FROM: Chris McDonald – Email: Chris@developingsvcs.com

RE: City of Mercer Island (CoMI)- Summary response to 2209-287-SUB1-PLANS_review-1.pdf

With the line entering the SFR at +/- 59.55 in elevation, and no connections exist below this POC into the SFR, no backflow valves are required for the private sewer portion of this residence.

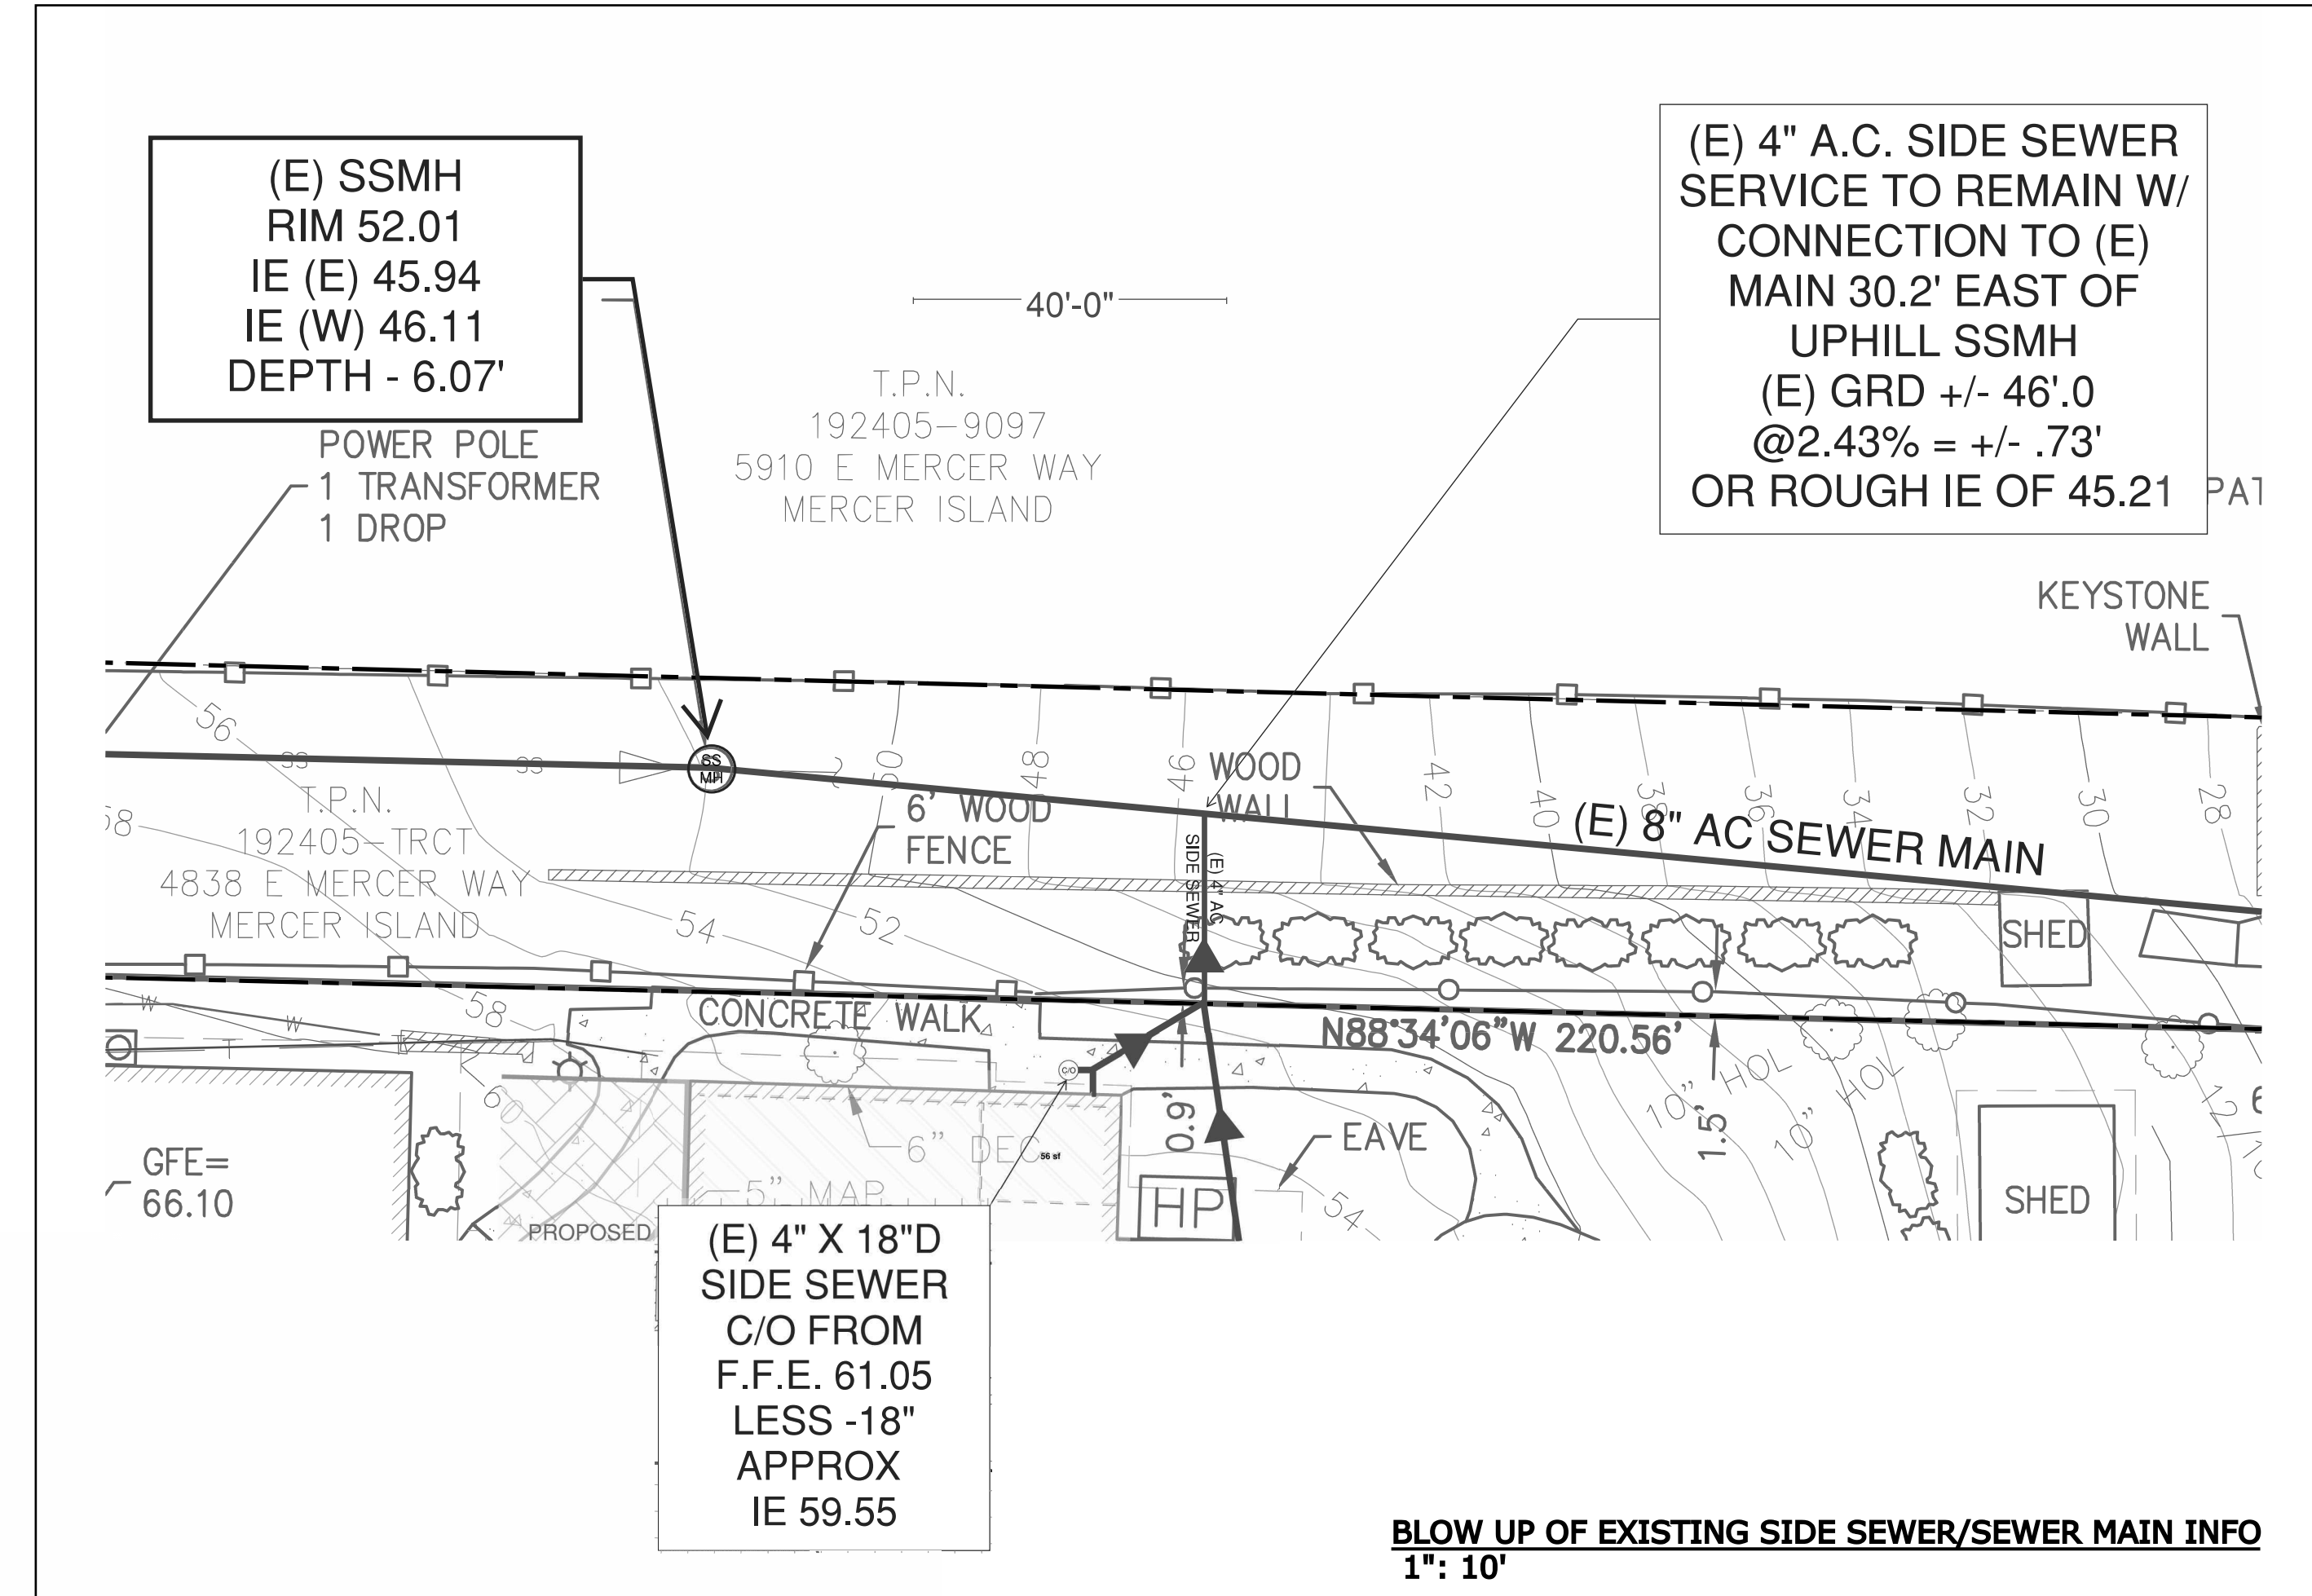
The site must have a sewer backflow prevention valve installed for the building, refer to the sewer standard details S-23 through S-26 for more information.

Details S-23 to S-26 make specific reference to “... *direct* side sewer connections from a residence to the Lake Line” only. This does not apply to our side sewer which, actually connects to a public main in an easement north of the property, and *that* public main connects to the Lake Line. Subsequent conversations between Kevin and I (**Chris McDonald**) concluded as much, and that the only concerns were that we confirm the lowest fixture on the side sewer connection from the home, is higher than the next upstream manhole. The below info is reflected on the sewer plan, and from either survey or As-Built data on record, and summarized below:

Upstream manhole info:

Rim 52.01
IE (E) 45.94
IE (W) 46.11

Existing SFR/SIDE Sewer:

SS Tap IE at public main	+/- 45.21
C/O IE at entrance to SFR	59.55 (18” below F.F./GRADE)
SFR main finish floor elevation	61.05 (+/- 15’ above low IE of upstream manhole)

All waste from the SFR is from 2 bathrooms on the main level, and a 3rd bath, in the addition on the south side of the home, which stacks with the 2nd bath. Below the main level is unhabitable space used for storage/ductwork/etc and contains no known plumbing, of which would require pumps/forcemain lines up to the waste line where it enters the SFR shown on the plan sheets
